Subject: RE: Planning Consultation on: AB/149/17/L

**Listed Building Consent for Alterations, Extension or Demolition of a Listed Building
APPLICATION AB/149/17/L**

Site Address: 44 Tarrant Street Arundel BN18 9DN

Description of Works: Listed building consent for internal alterations & renovations

Drawing No
171164/ 105

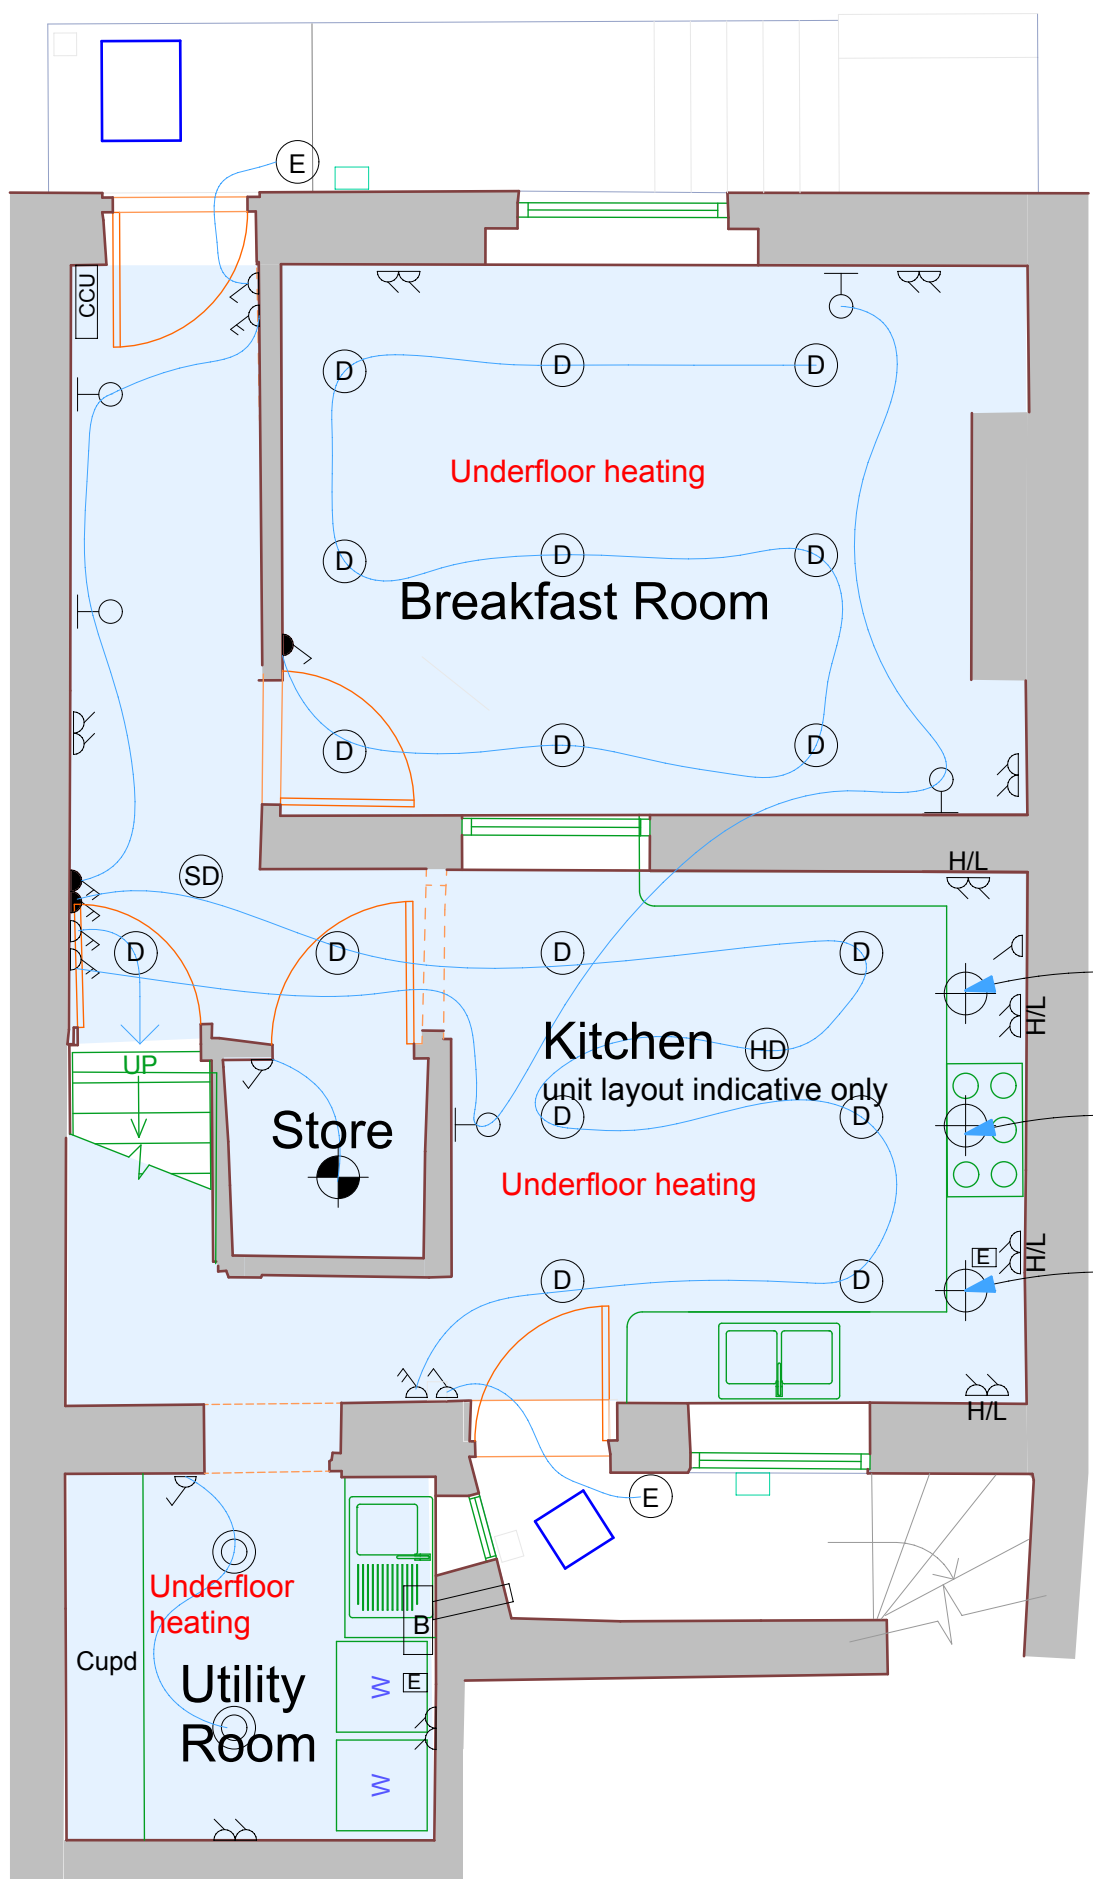
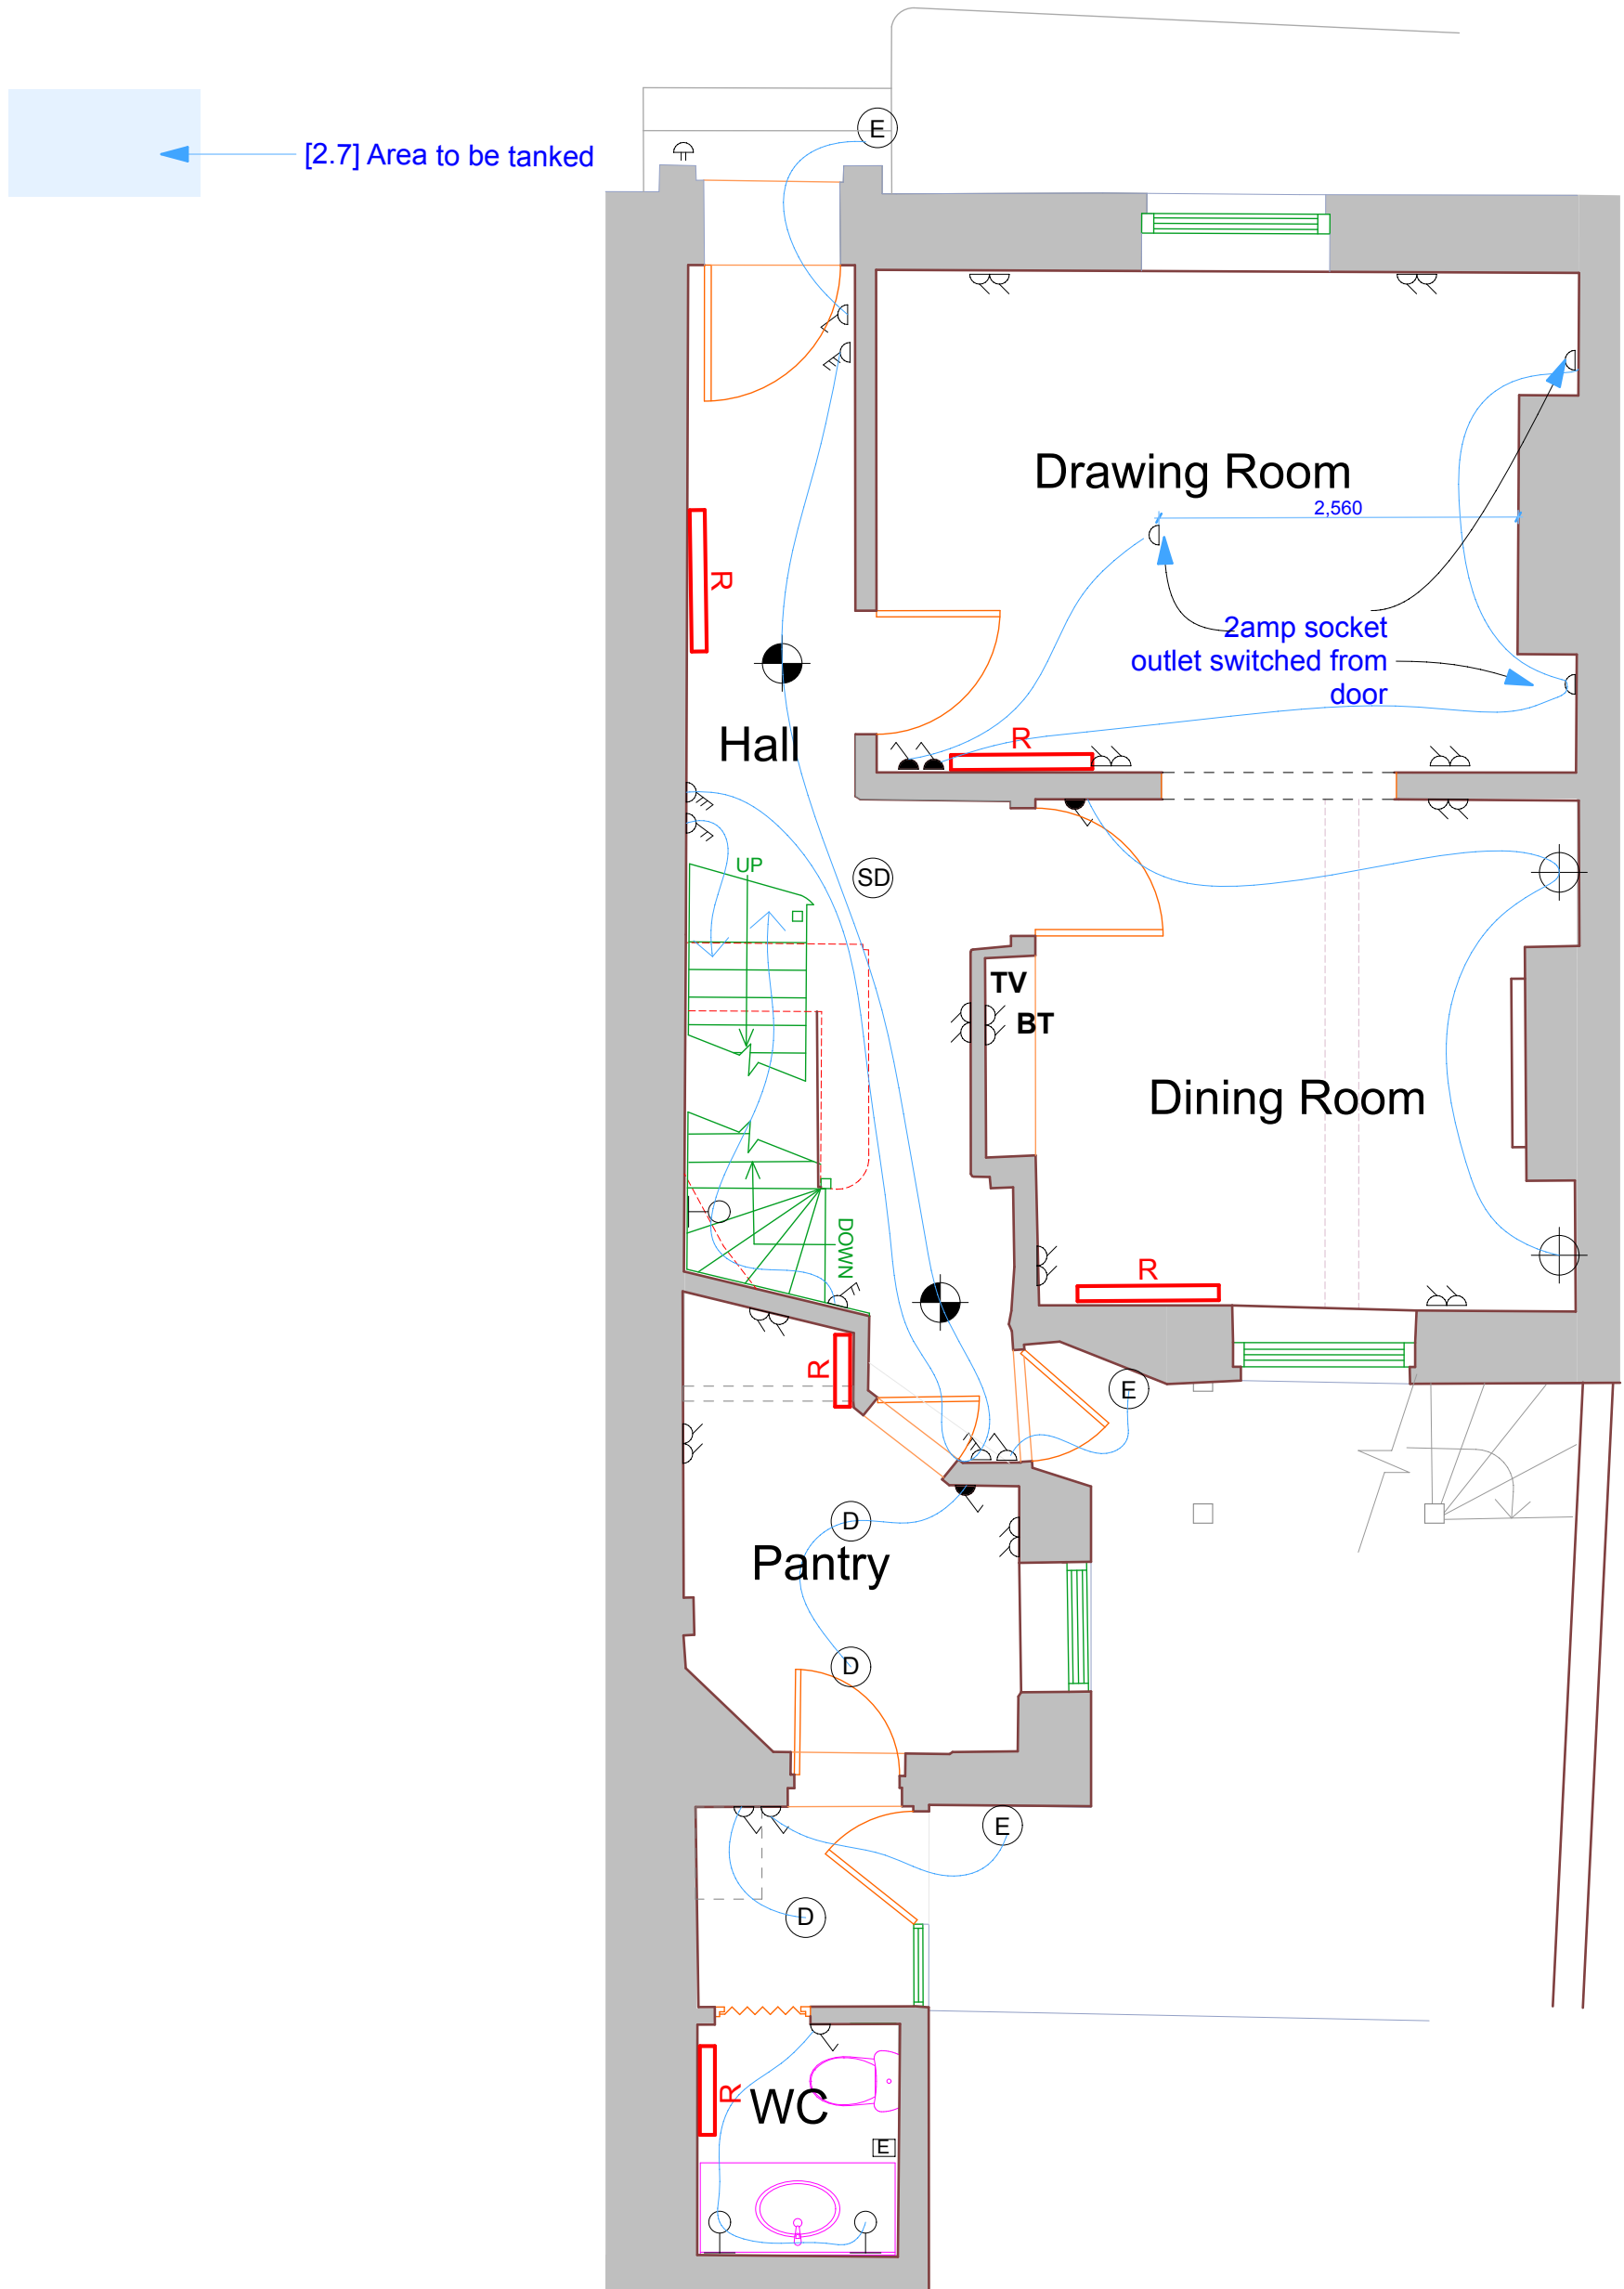
- The installation of downlighters other than to 2ndFloor where dropped ceiling is evident. The introduction of these is disruptive to historic fabric.
